**CATHERINE CHAPMAN
WRITTEN REPRESENTATION**

**WITH REGARD TO THE APPLICATION BY HIGHWAYS ENGLAND
A428 BLACK CAT TO CAXTON GIBBET ROAD IMPROVEMENT SCHEME
(TR010044)**

**ON BEHALF OF MCDONALD'S RESTAURANTS LTD
McDONALD'S CAXTON GIBBET (STORE #1416) AND;
McDONALD'S WYBOSTON (STORE #543)**

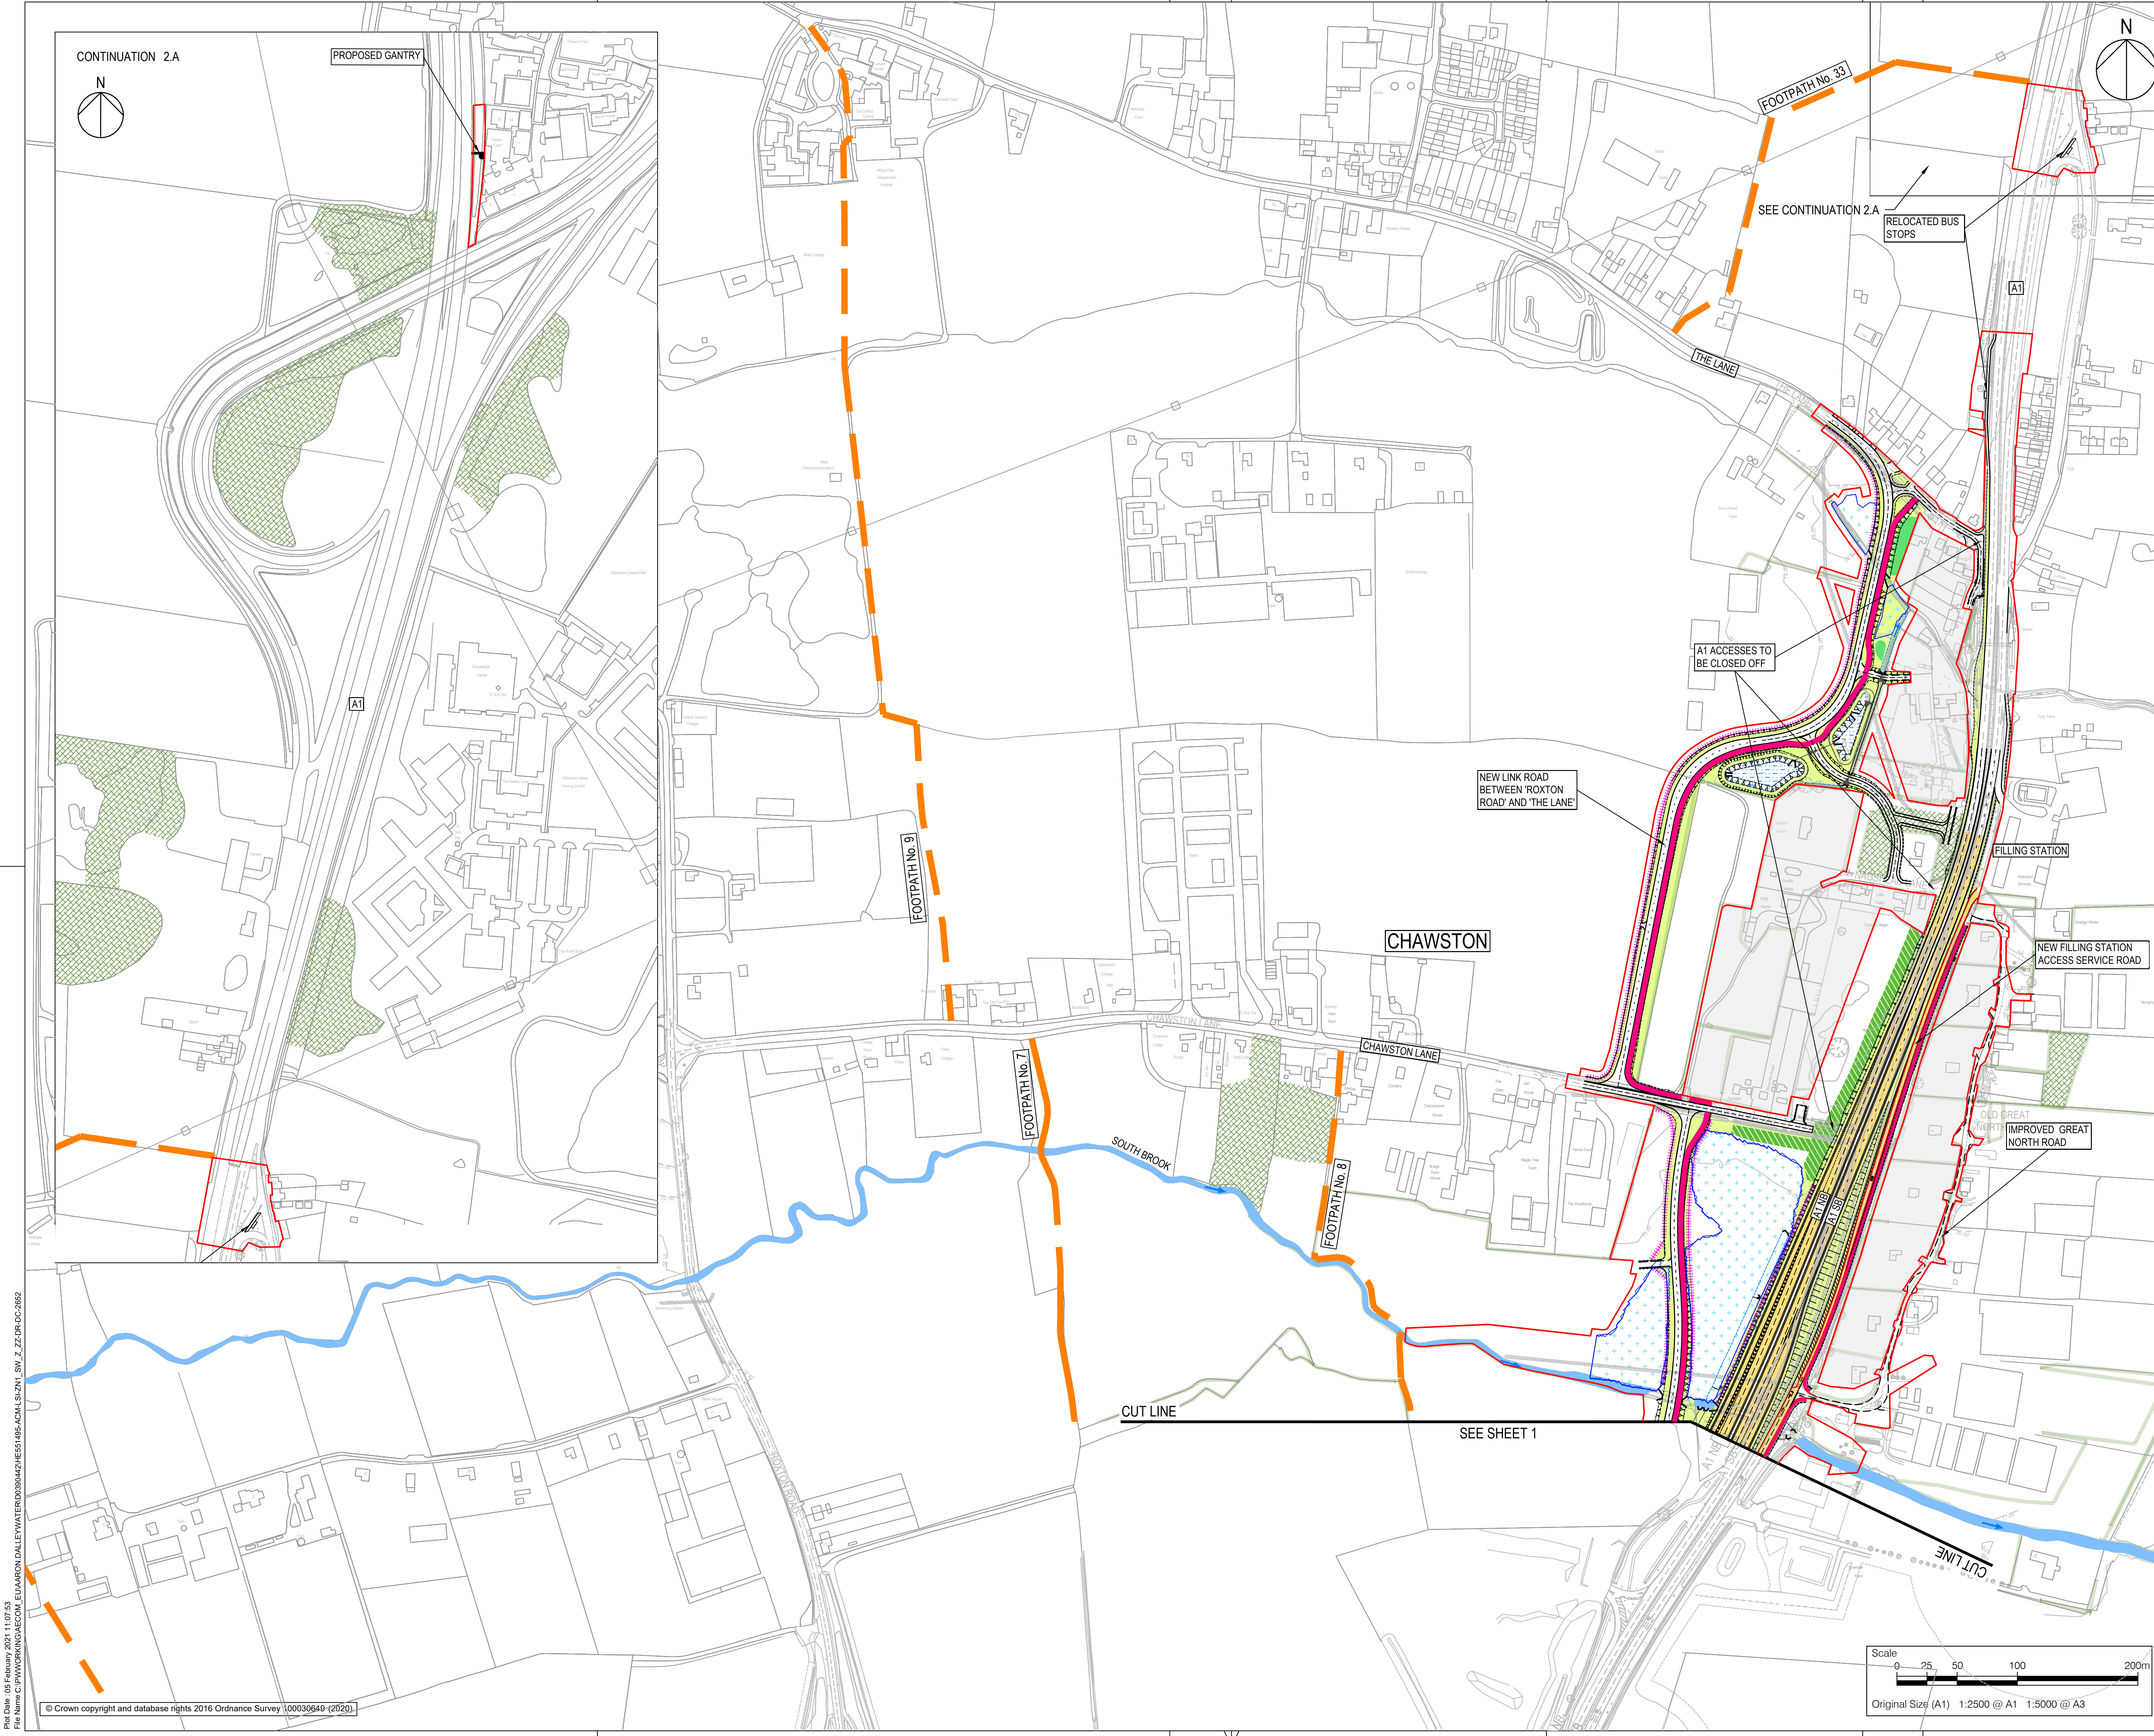
3.2.1 The Highways England proposals for the Wyboston Services are shown on the General Arrangement Plans Regulation 5(2)(O) Sheet 2 dated 05/02/21. The extract provided as Figure 3B shows that the access left in would be retained from the A1 (Southbound). However, the egress to the Services would be modified. There would be no direct egress to the A1. Customers would egress via a new access link running parallel to the A1 which would also serve Great North Road back to the Black Cat Junction.

3.2.2 No signage plans have been provided. It is considered that there would be a considerable distance for customers to travel before they get back to the A1. Appropriate and adequate signage needs to be provided to ensure customers are confident that they are being correctly directed back to the A1. In addition, signage is required to ensure customers do not try and access the restaurant from the Black Car Roundabout via Great North Road (i.e., try and enter via the egress having travelled 1km up Great North Road to find this is not an access route) which would be a highway safety issue.

- 4.3 No signage plans have been provided to support the Highways England proposal alterations to the egress of the Services at Wyboston. No information has been provided to demonstrate that customers will be informed on the egress route back to the A1 or that appropriate signage will be provided to ensure that customers do not try and access the restaurant via the new link.

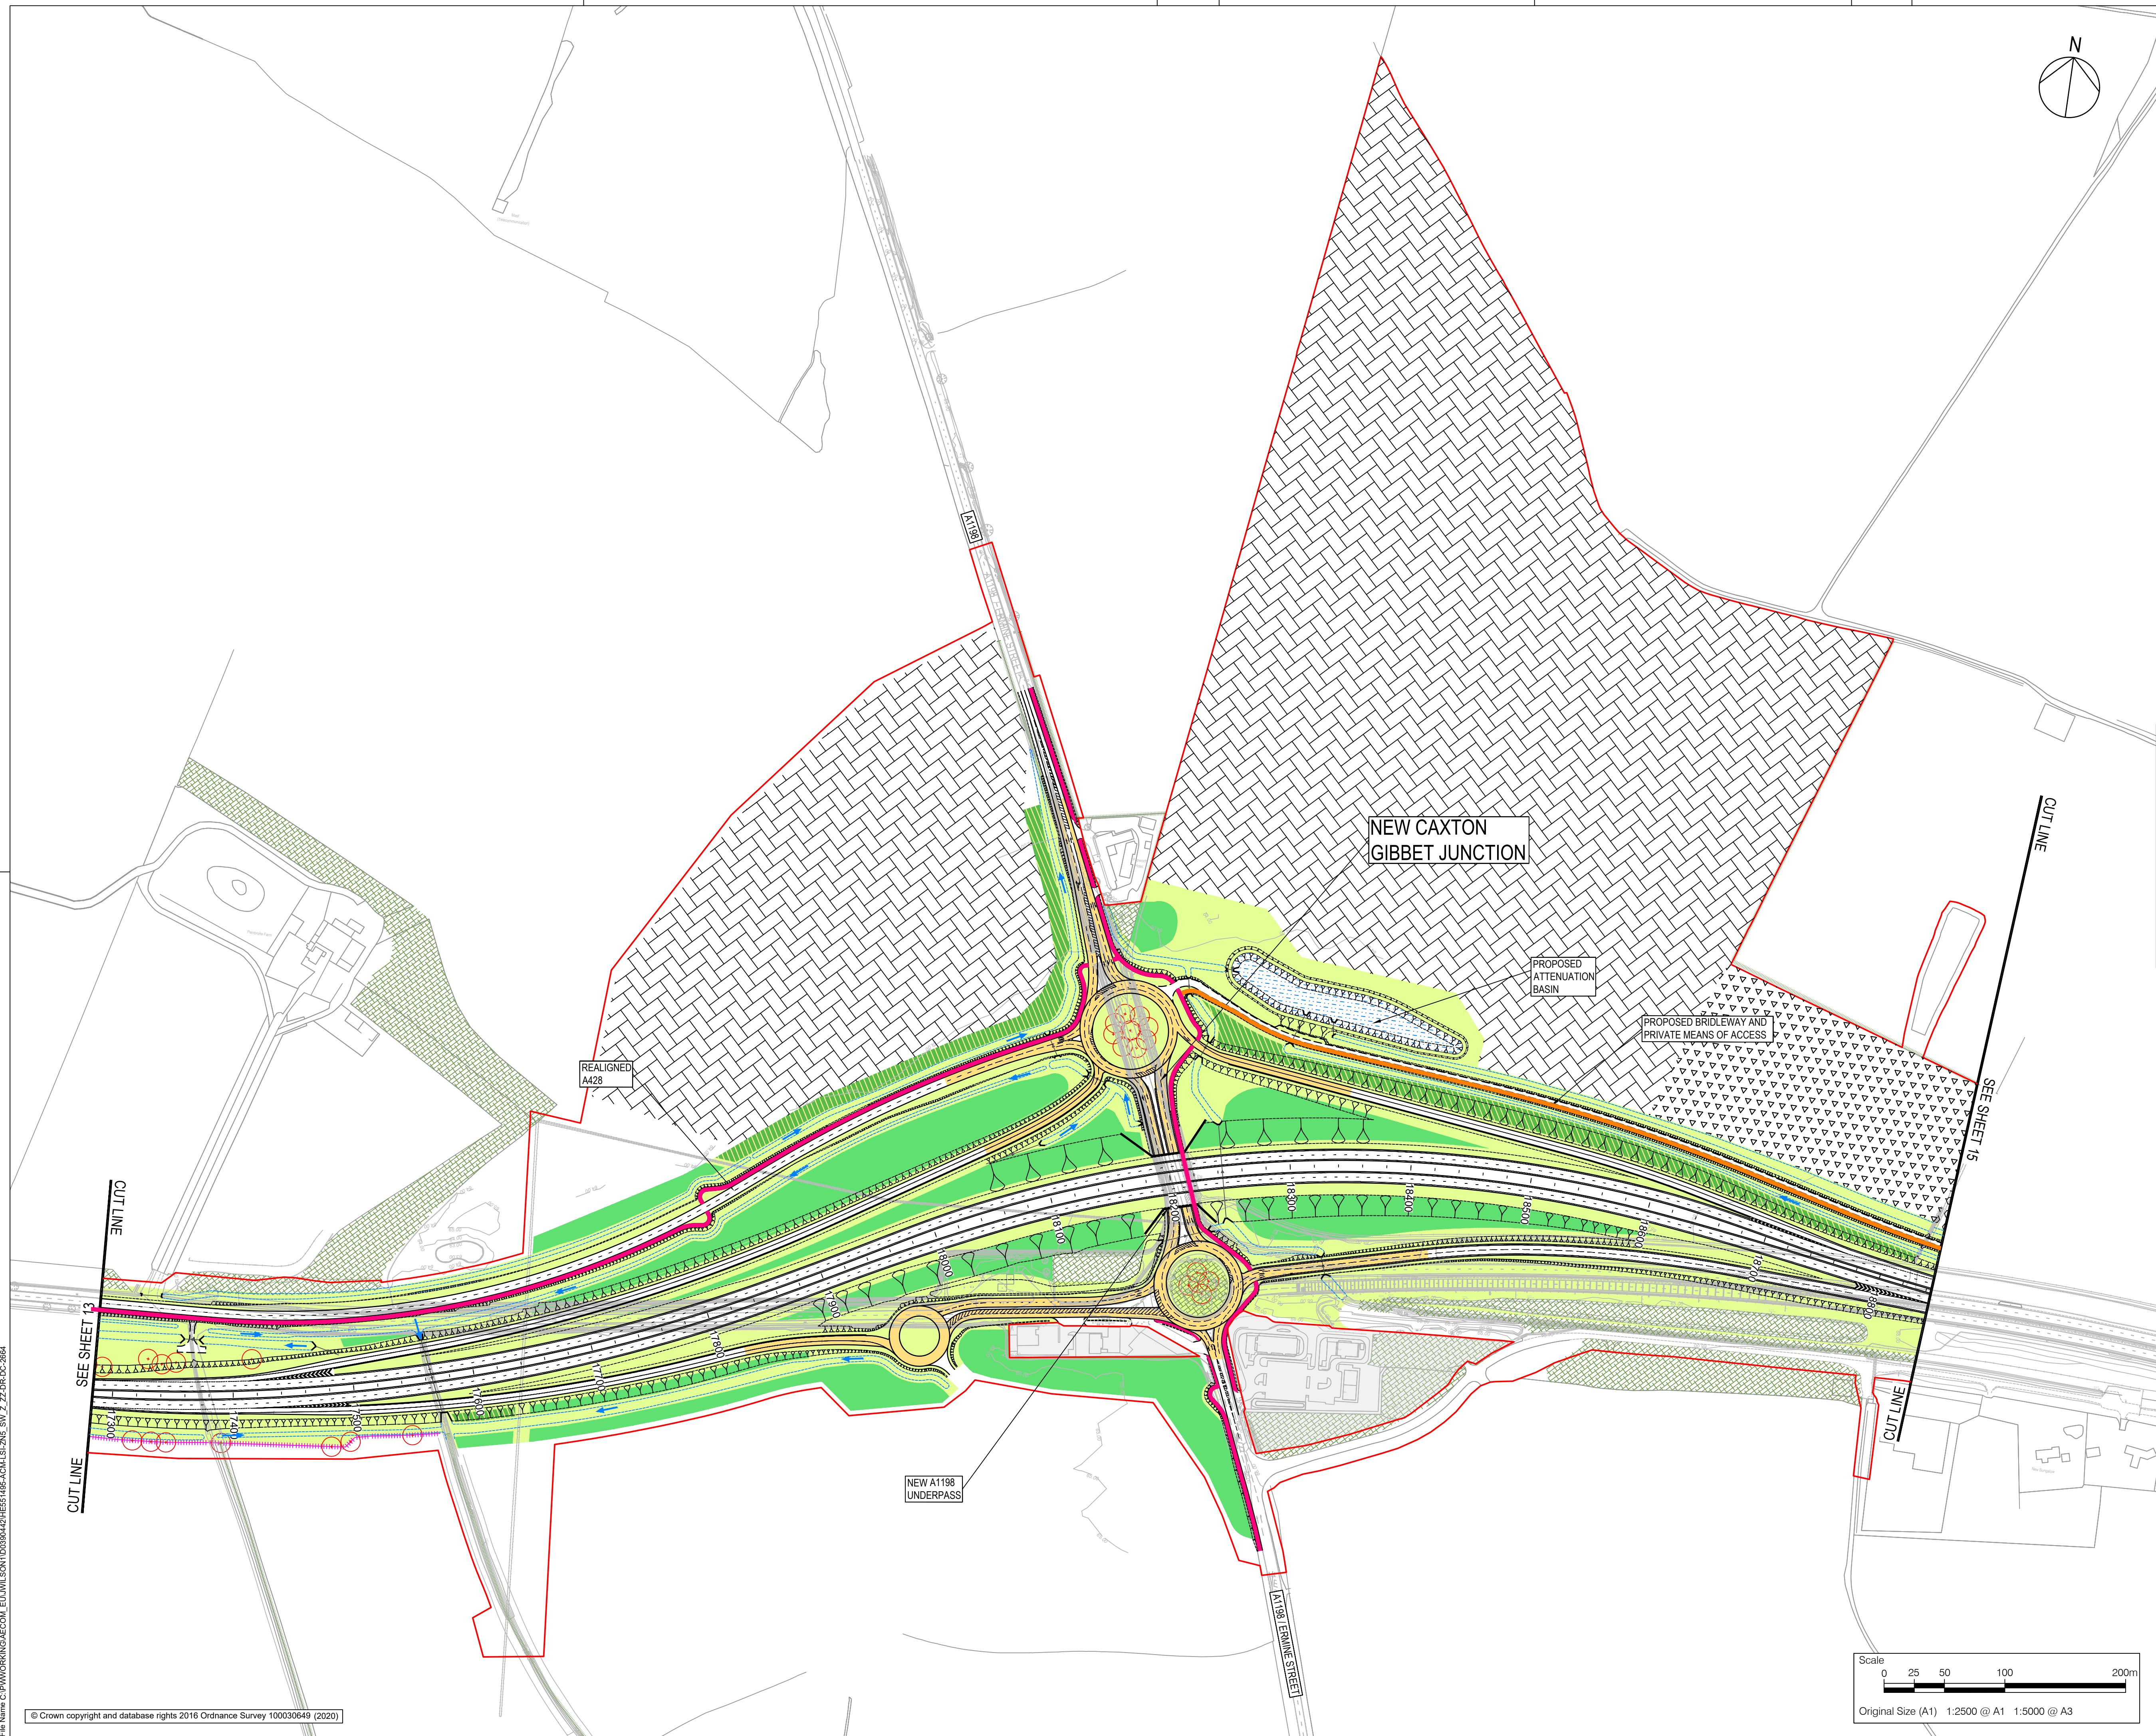
2.4.1 The Highways England proposals for the Caxton Gibbet Roundabout are shown on the General Arrangement Plans Regulation 5(2)(O) Sheet 14 dated 05/02/21. The extract provided below as Figure 2B shows that the right turn lane facilities for the Service Area and the Self Storage/Agricultural Access would be removed. This would be contrary to CD123 Guidance for the Services Access arrangements.

2.4.2 The provision of an uncontrolled pedestrian refuge on a 50mph road does not comply with CD143 guidance. In addition, customers to the Services Area turning right in would have to cross the hatching provided to the south of the refuge.

- 2.4.3 No signage plans have been provided to support the Highways England proposals. The proposed dumbbell roundabout arrangement requires customers to make a decision to leave the A428 via the slip roads much earlier than with the existing roundabout arrangement. Therefore, signage for the services will be essential to ensure motorists can make safe and timely decisions if they wish to visit the services. I have provided a plan showing the signage requirements we consider should be provided for Caxton Services as Appendix CMC 5.0.

- 2.4.4 In summary the access proposals for the Caxton Gibbet Services area are inadequate and contrary to Highways England own design standards. The siting of the pedestrian refuge and crossing provision are also unacceptable. These need to be reviewed and the right turn lane facilities for the Service Area and junction to the south maintained. Signage plans need to be provided which demonstrate that consideration of the operation of the Services Area has been properly taken into account.

- 4.2 The Highways England access proposals for the Services at Caxton Gibbet are inadequate and do not comply with the appropriate design standards. The right turn lane for the Services and the Access Road to the south should be reinstated. The proposed pedestrian refuge should also be reconsidered. No signage plans have been provided to demonstrate how motorists will be informed in their decision making to visit the Services.
